Application 3/2023/0866 - Land adjacent to 9 Old Road Chatburn BB7 4AB

Please find below comments and representations on Application 3/2023/0866 - Land adjacent to 9 Old Road Chatburn BB7 4AB.

Drawing Title
Proposed Boundary Fence
And Wall Details

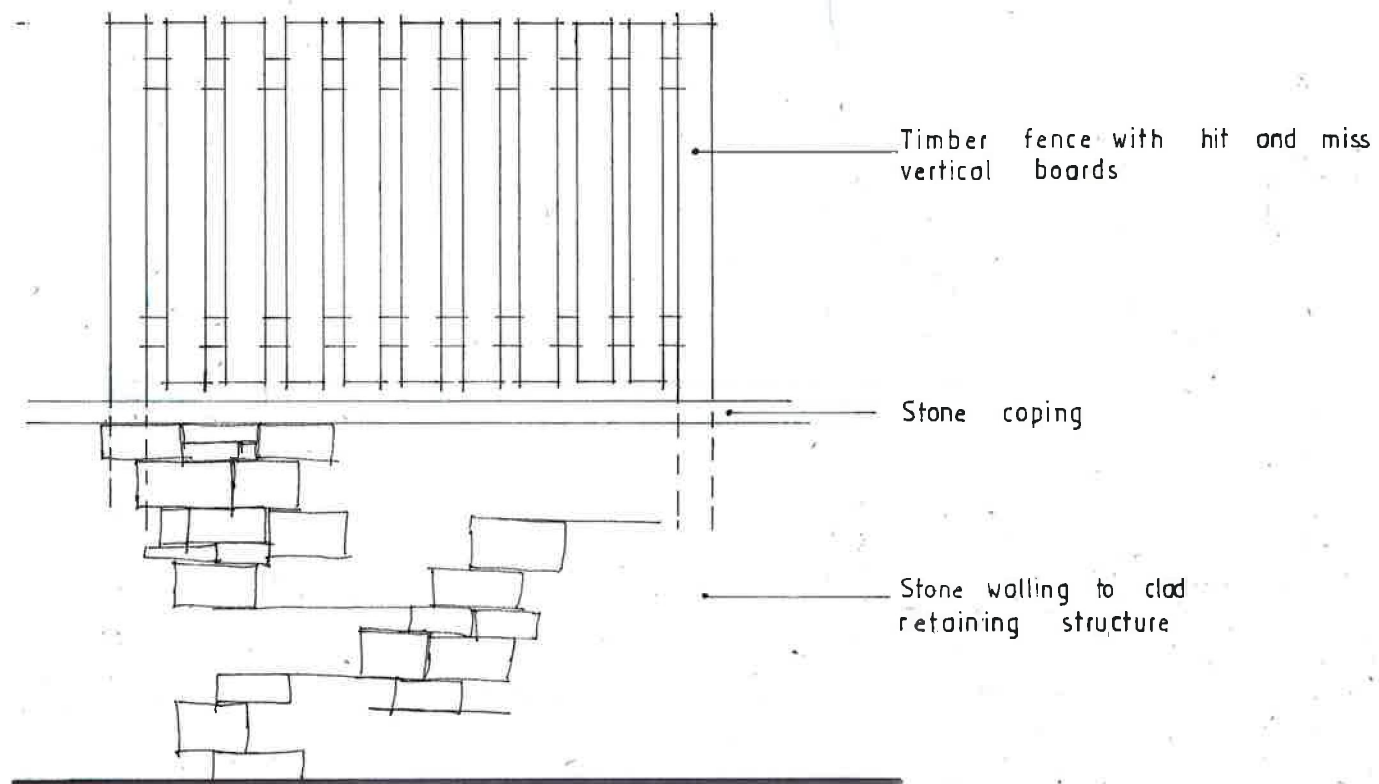
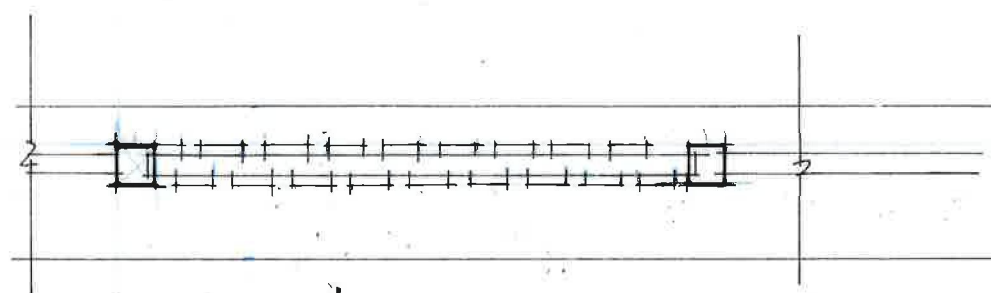
4. There is no detail for how a retaining structure is to be created to hold back the gardens of 1-2 and 3 Hare Hill Croft. A hand drawn, [REDACTED] drawing of the facia of this structure is included but no detail of the structure or its construction method is provided. The earth that would need to be excavated, is the very same soil that the applican [REDACTED] later testifying to the Planning Inspectorate that this was required to "shore up" the foundations and gardens of 1-2 and 3 HHC (Hare Hill Croft). How can this now be safely removed without providing an adequate retaining structure? Surly the removal of this soil will invalidate the findings of the Planning Inspector and render her finding null and void.

Title
Landscape Strategy - 1 Plot

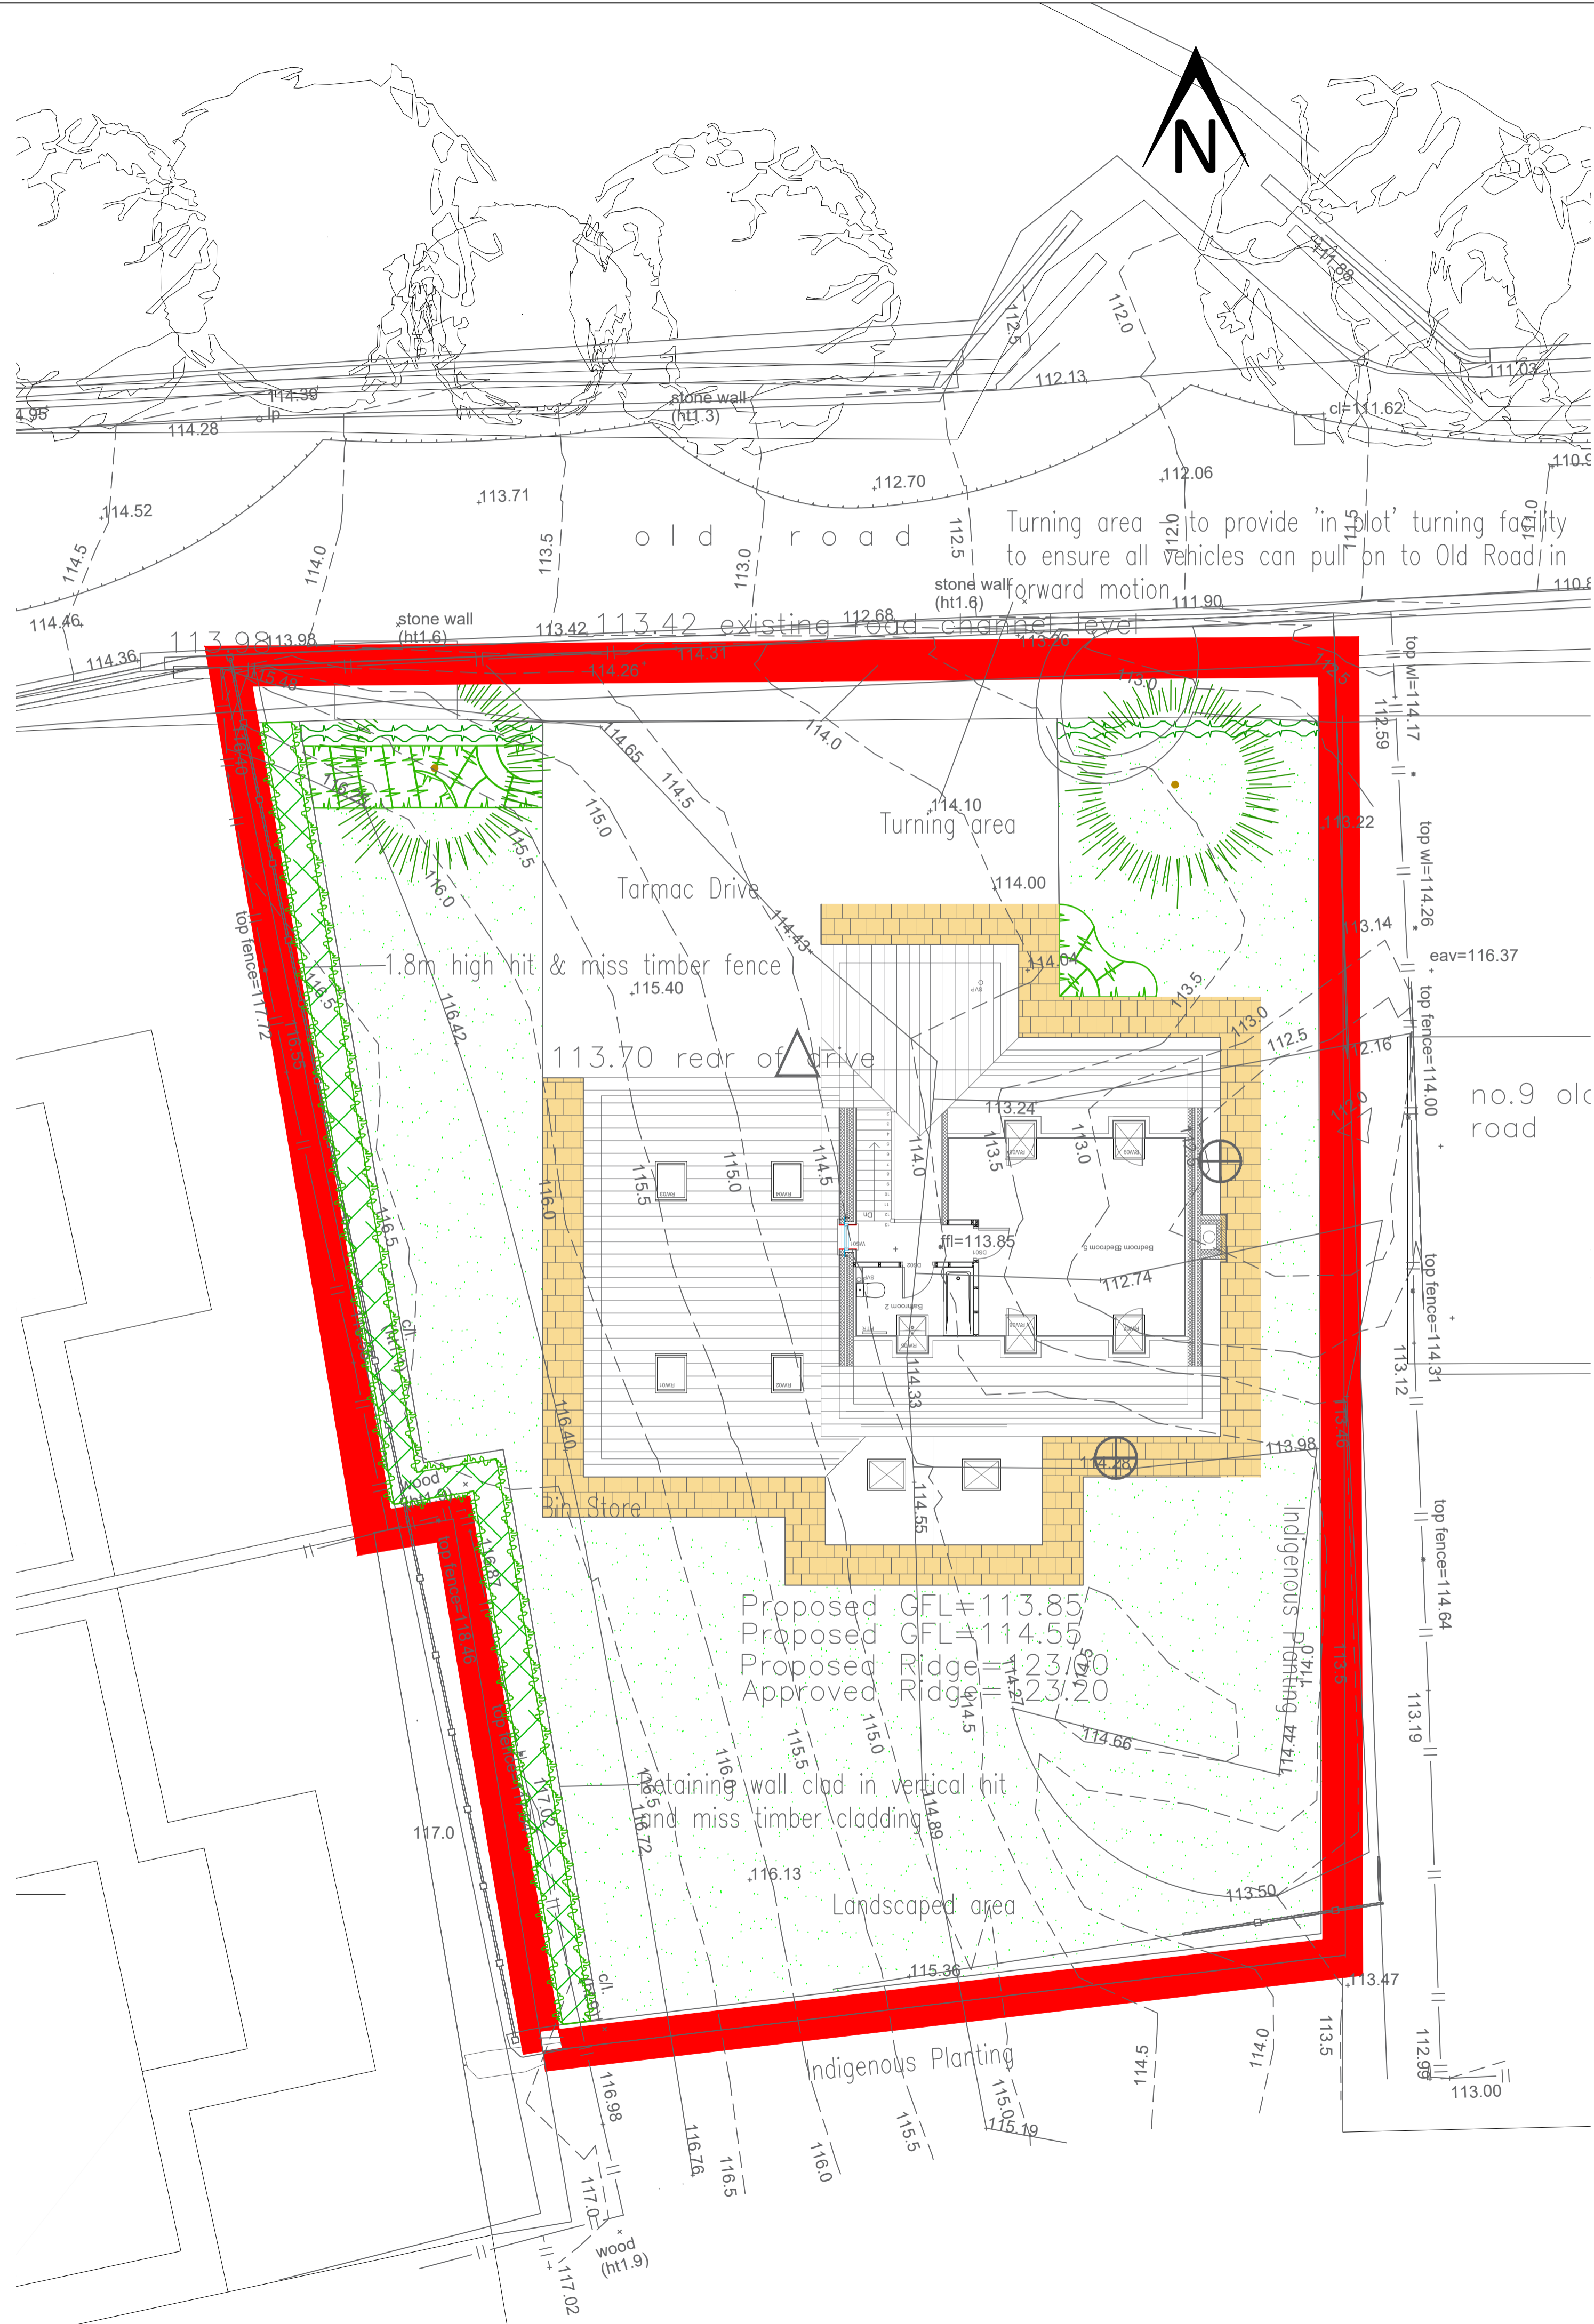
Extract from this drawing (below) shows the proposed landscape details. Planting is shown at high level as well as a low-level path around the property at ground floor level. A 1.8m high timber fence detail is provided (Drawing 23\_0866\_Boundary\_Fence\_Wall\_Details\_7feb24) which imposes significant wind loading on the retaining wall structure. All of these points suggest the details as submitted will not be buildable without encroaching into the HHC properties gardens.

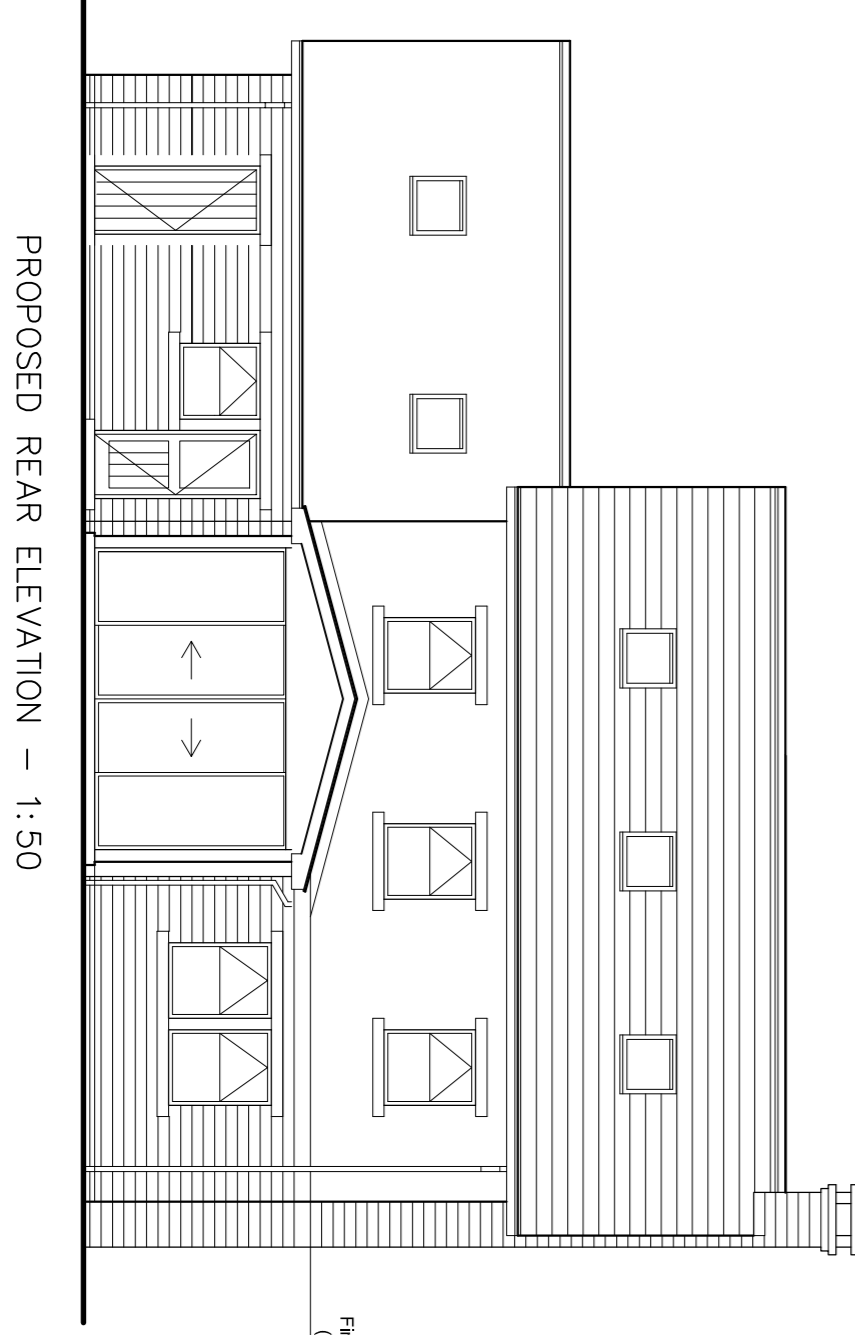
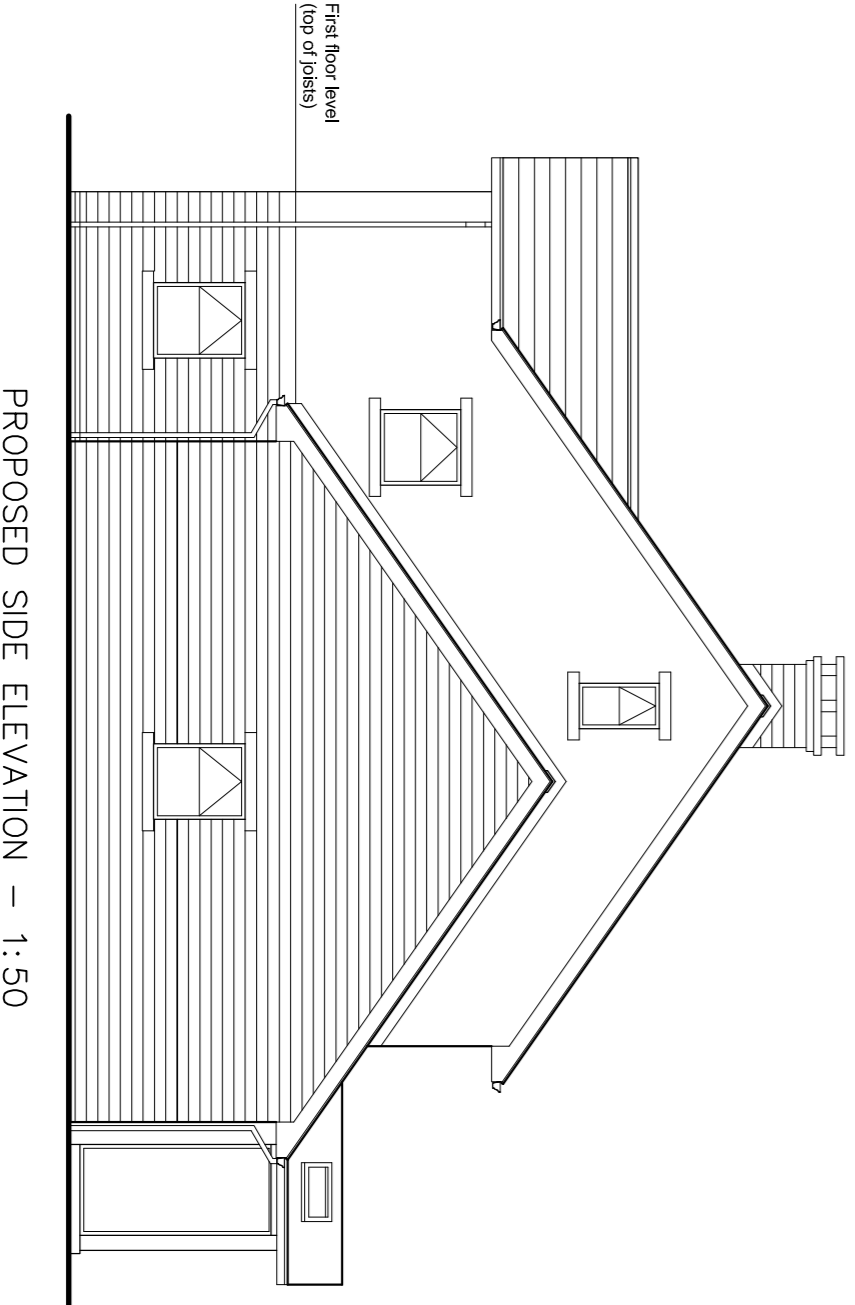
2. 23 0866 Plans and Elevations drawing makes no sense. It shows the house to be on level ground with the garage at the same level as the house, whereas the slope on Old Road make a construction like this impossible.

Drawing Title
Sections

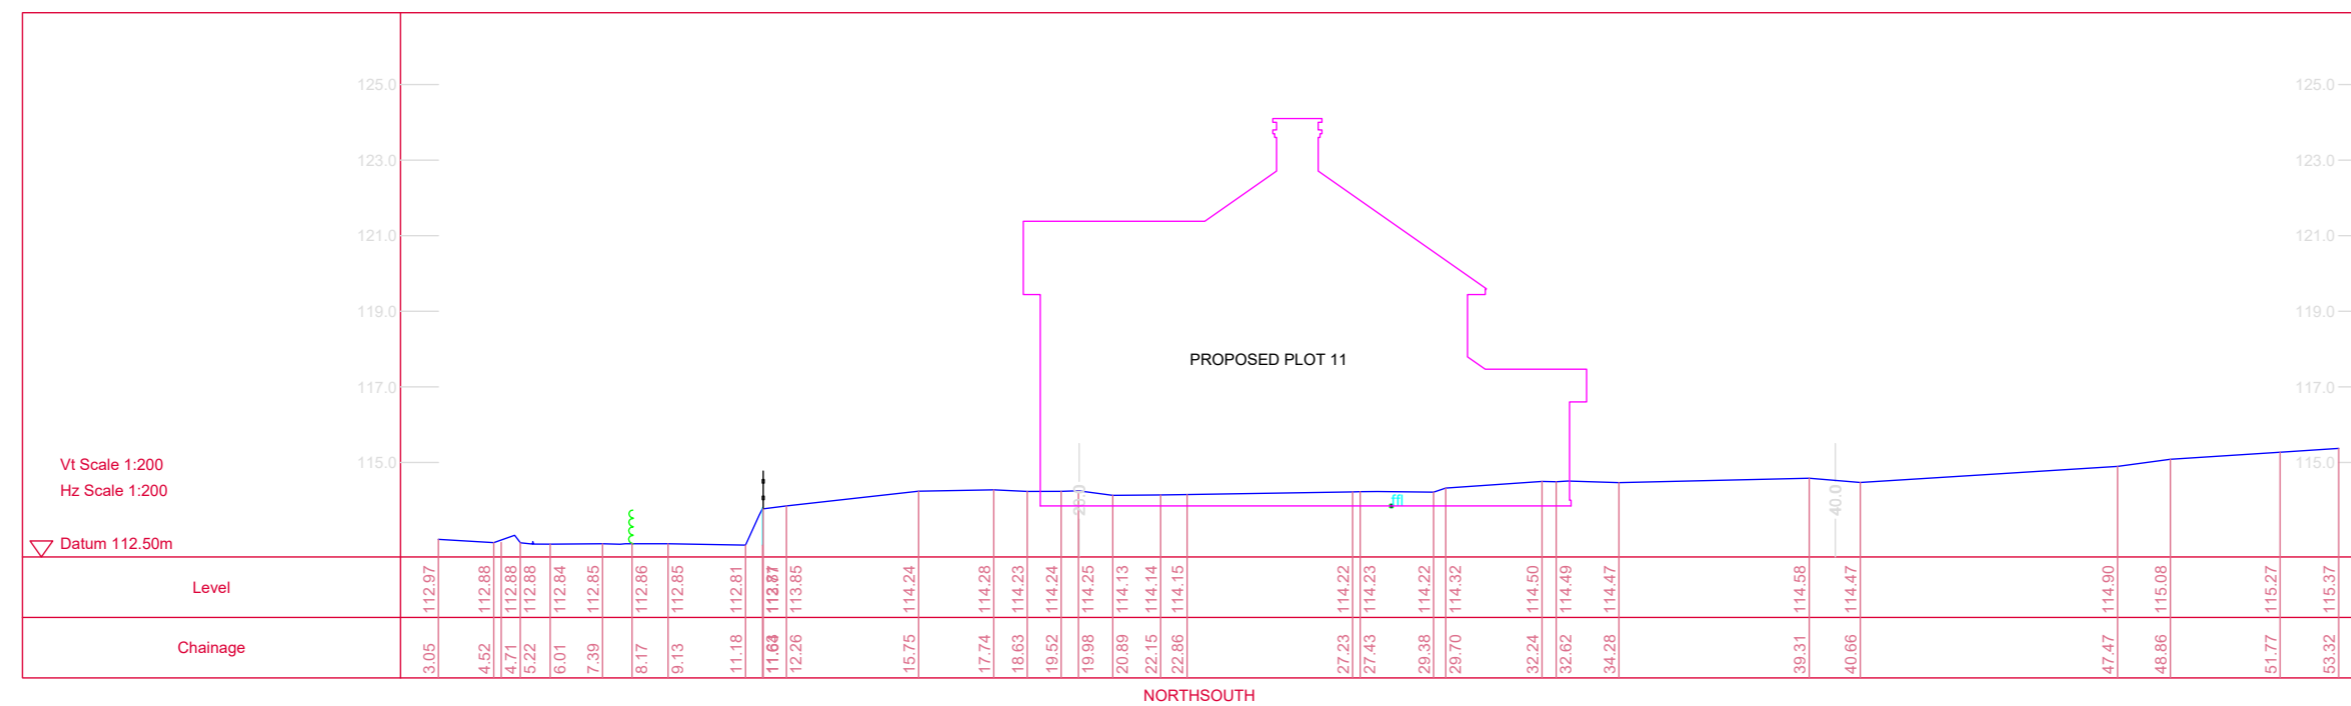
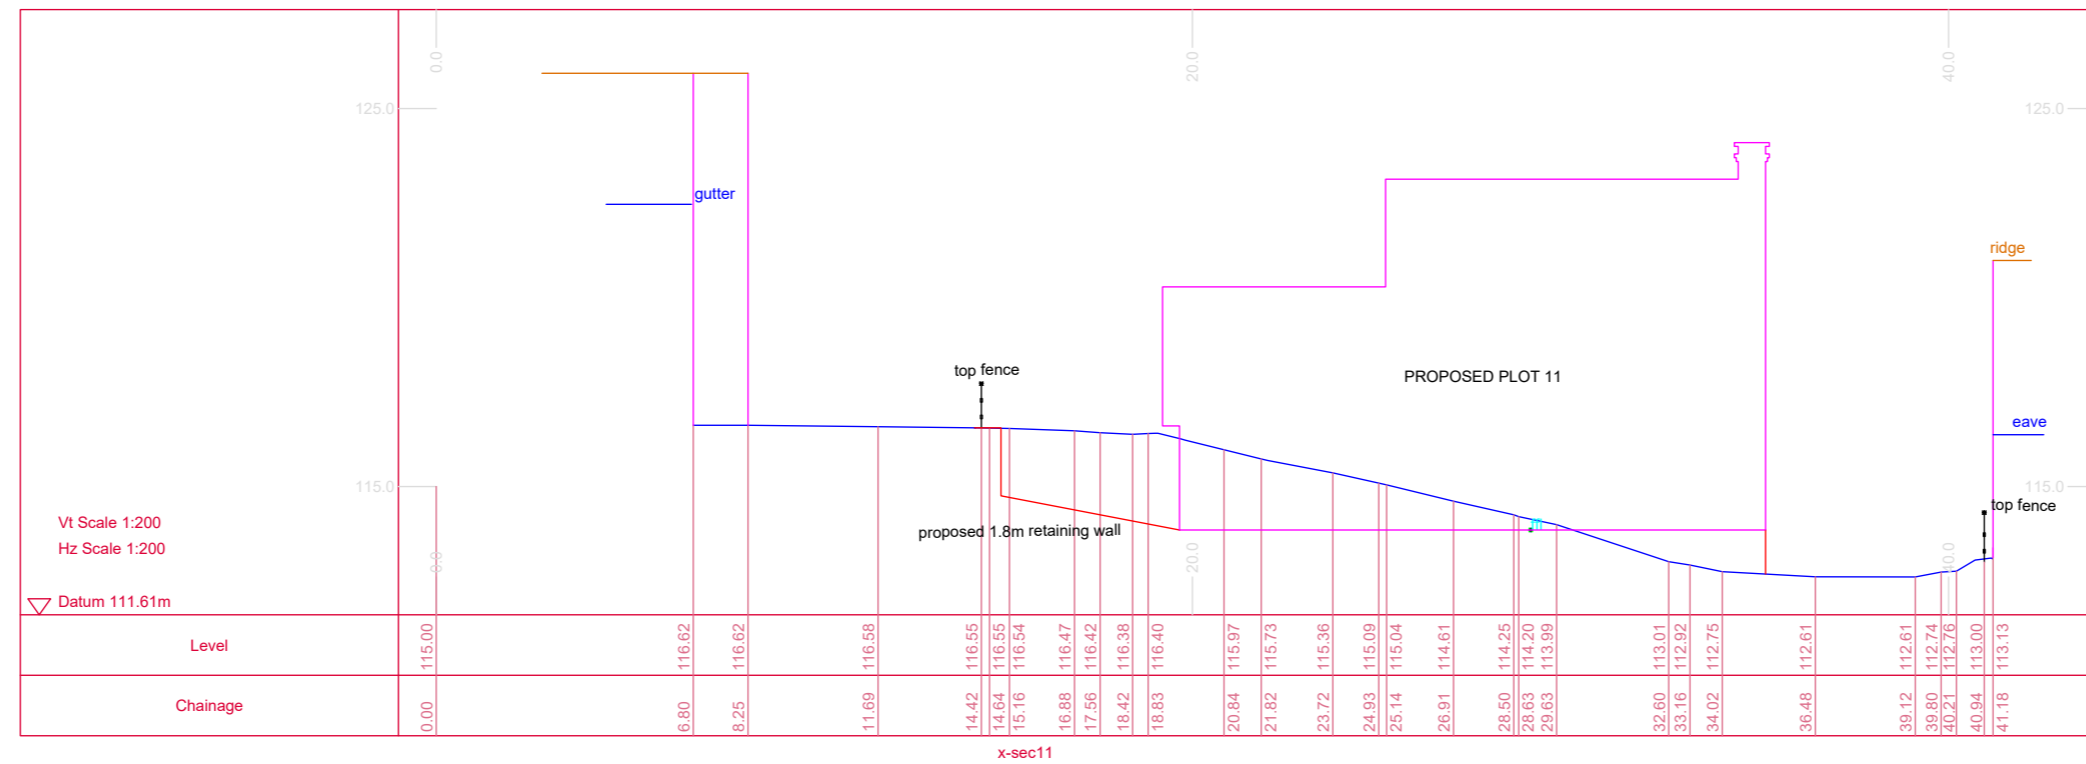
Section ref. 'x-sec 11' shows a proposed 1.8m retaining wall immediately in front of the land (existing fence line) boundaries of No.1 & 2 Hare Hill Croft (HHC).

The existing ground level at the NE corner fence line of No.2 HHC is 116.87 from the topographical details provided and the FFL of the proposed dwelling is 113.85. The level difference between these two points is therefore 3.02m. The plan distance from the NE fence line corner of No.2 HHC to the SW corner of the proposed dwelling is c. 3m. The actual depth of excavation required for both foundations and retaining wall will inevitably be below FFL ie greater than 3.02m. A 1.8m retaining wall is insufficient and the location of the current cross section and way it is drawn oversimplifies the issue.

From earlier comments I have queried the engineering qualities and specification for the original placement of the existing bulk fill that was imported during the HHC construction. These details need to be known in order to design and assess any retaining wall options.

In addition, the location of the proposed retaining wall is close to the existing boundaries of No's 1 & 2 HHC which inevitably means an easement into the gardens of No's 1&2 HHC would be required to facilitate construction of the

proposed retaining wall. The authority should seek full details of the proposed structure and its method of construction to be satisfied that the proposals will not adversely affect the HHC properties.
